**STATE SIGNIFICANT DEVELOPMENT:
Section 96(2) Modification**

***Sydney International Convention, Exhibition
and Entertainment Precinct (SICEEP), North
West Plot, Darling Square (formally The
Haymarket), Darling Harbour***

SSD 6013 MOD1

Secretary's Environmental Assessment Report
Section 96(2) of the
Environmental Planning and Assessment Act 1979

Figure 3.11 : Section 96 NW Plot proposed building east west section with Parameter Plan envelope overlay

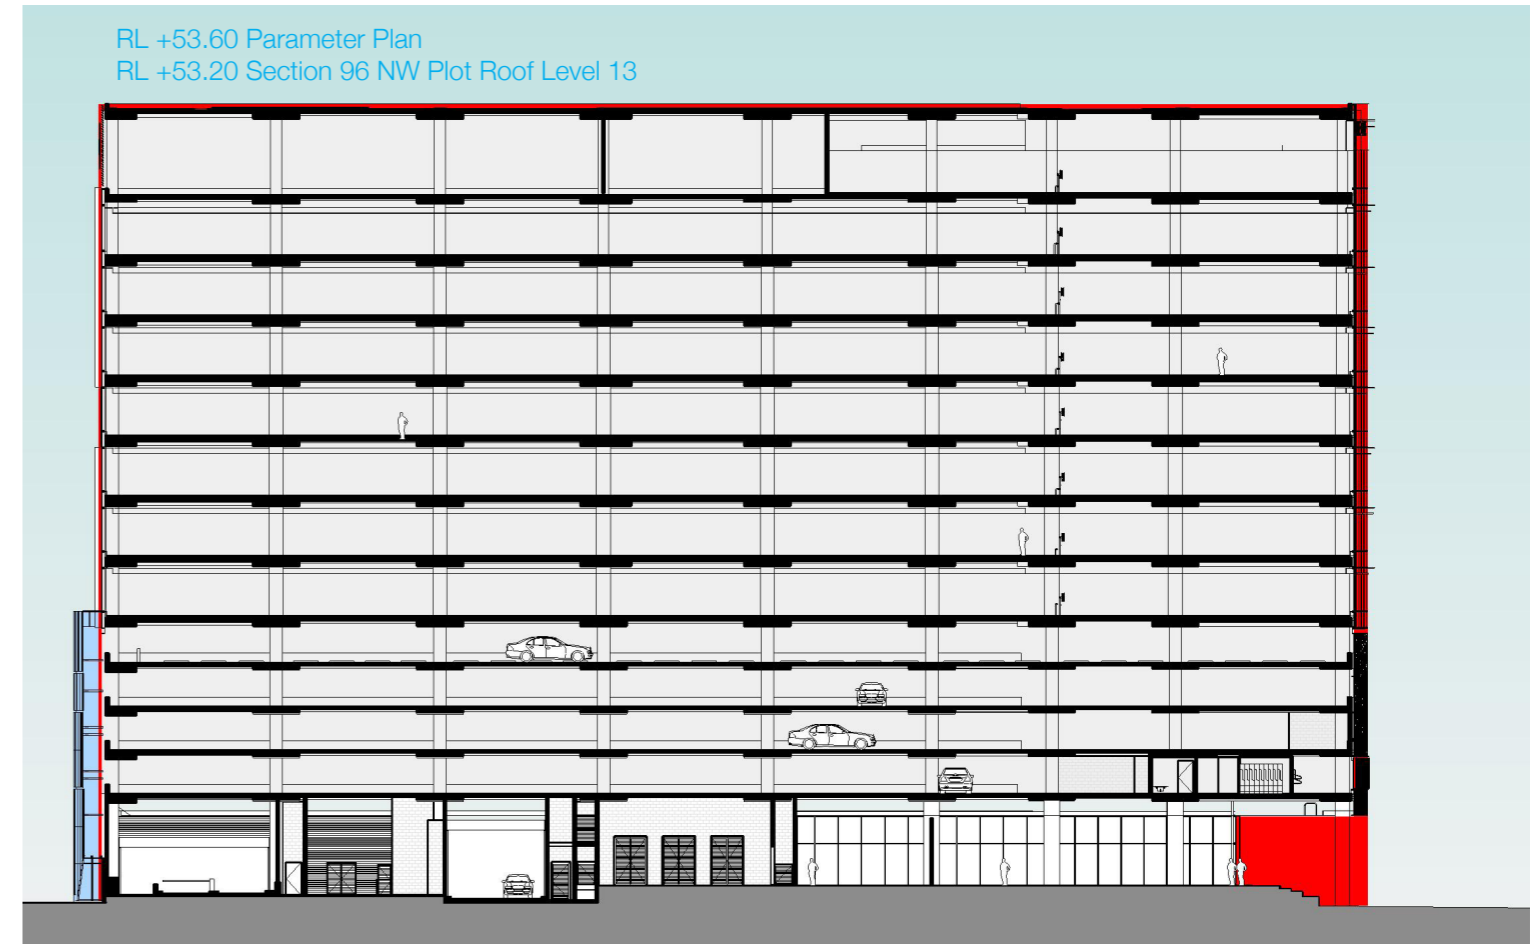
The applicant contends that the proposed two metre projection on the western façade on Darling Drive (identified in green in **Figure 5**) is necessary to accommodate a structural column and cladding to support the carpark levels, while avoiding interference with the existing subterranean service culverts. In response to this constraint the applicant has designed the structural support as an architectural feature of the building, providing additional articulation and visual interest. Further, the car park cladding is articulated to align with the podium of the approved mixed use building on the South West Plot (**Figure 6**).

The design of the encroachment as an architectural feature and relationship to the South West Plot provides a considered response to the constraints of the subterranean culvert in this location. While this encroachment will add some bulk to the western façade, this corner of the building is not highly accessible given its location adjacent to the Pier Street overpass and theatre access road. The Department considers that the proposed encroachment is acceptable because:

- the extent of the encroachment is minor in the context of the scale of the proposed building;
- it is necessary for the functioning of the building;

- it is well integrated in its design; and
- it is consistent with the approved building on the adjacent South West Plot.

Further, as the encroachment relates to a discreet element of the building, the Department is satisfied that the proposal remains generally consistent with the Stage 1 Concept Approval.
